Our Ref: PA/JCG21508
Your Ref: A/9/18/PL

Date: 1st June 2018

PLANNING APPLICATION REFERENCE: A/9/18/PL
THE CARAVAN SITE, NEW ROAD A259, RUSTINGTON
APPLICATION BY MR T CASTLE
PROPOSED CHANGE OF USE OF LAND TO A GYPSY AND TRAVELLER CARAVAN SITE

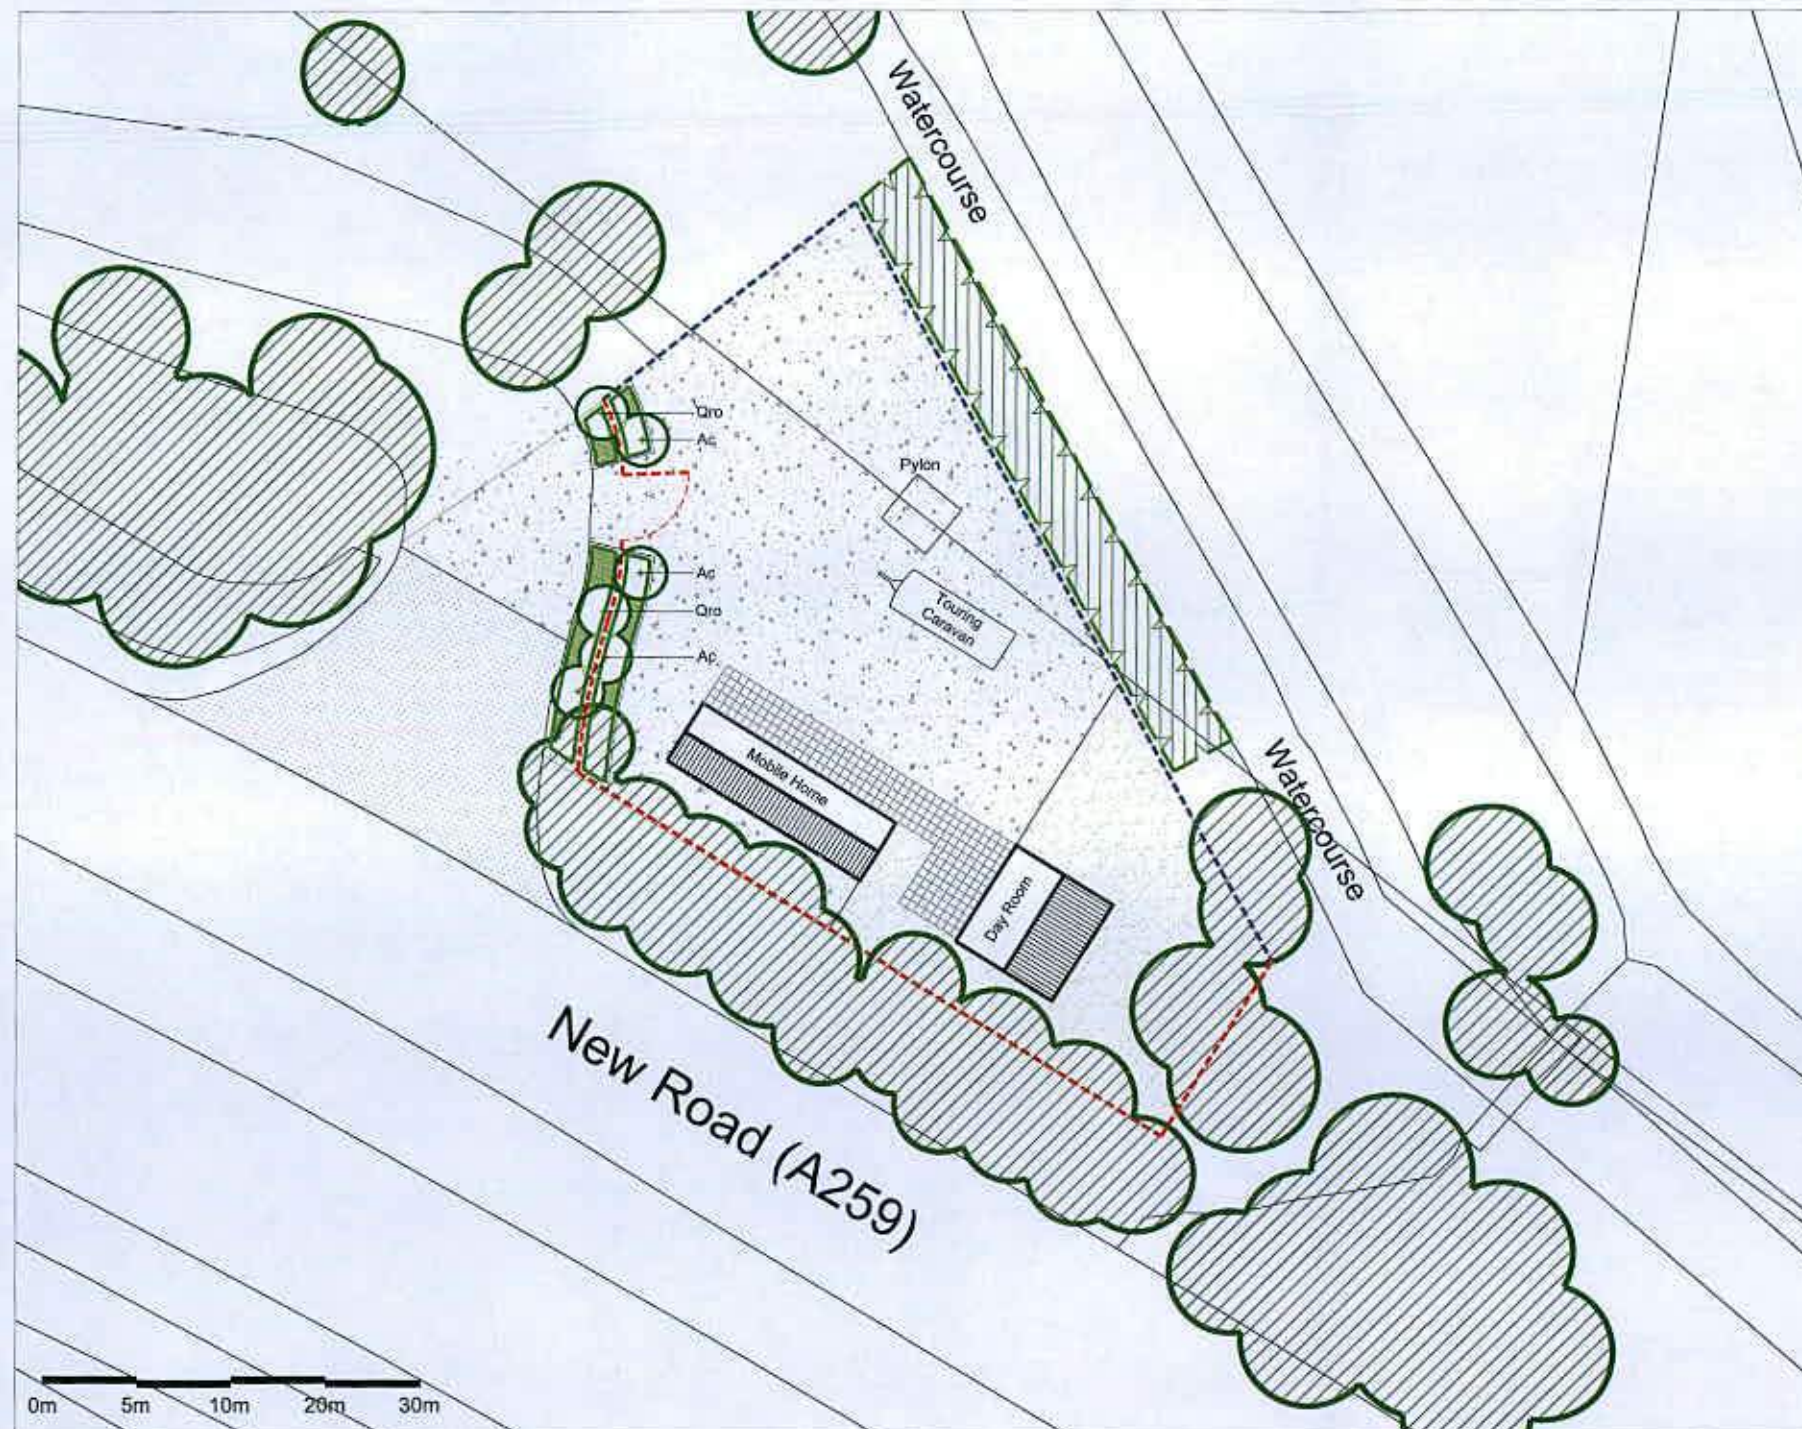
The submitted site plan shows provision for two parking spaces, perimeter fencing including an acoustic fence to the A259, landscaping including proposed tree planting and a grass play area. Significantly, the majority of the site is shown as a proposed 'parking area and courtyard area'. Vehicle access to the site is proposed via the existing access arrangement directly from the A259.

Whilst the application site has direct access to the A259, no improvements are proposed to assist the safe access and egress to the site. The existing access arrangement is a potential danger to the safety of the highway. Furthermore, the application proposals provide no safe means of access by foot or cycle and in this respect the site is isolated from nearby settlements where local services are provided. The proposals therefore fail part c) of draft policy H SP5.

Although the applicant is proposing to erect an acoustic fence along the A259, no evidence is presented to support the effective of this fence to mitigate noise. The Council should reasonably request relevant technical assessments from the applicant.

The large area of proposed hard standing has the potential to attract significant additional activities, structures and the parking of vehicles in this countryside location which could result in a more intensive use of the site, harmful to the visual appearance of the area if not properly controlled.
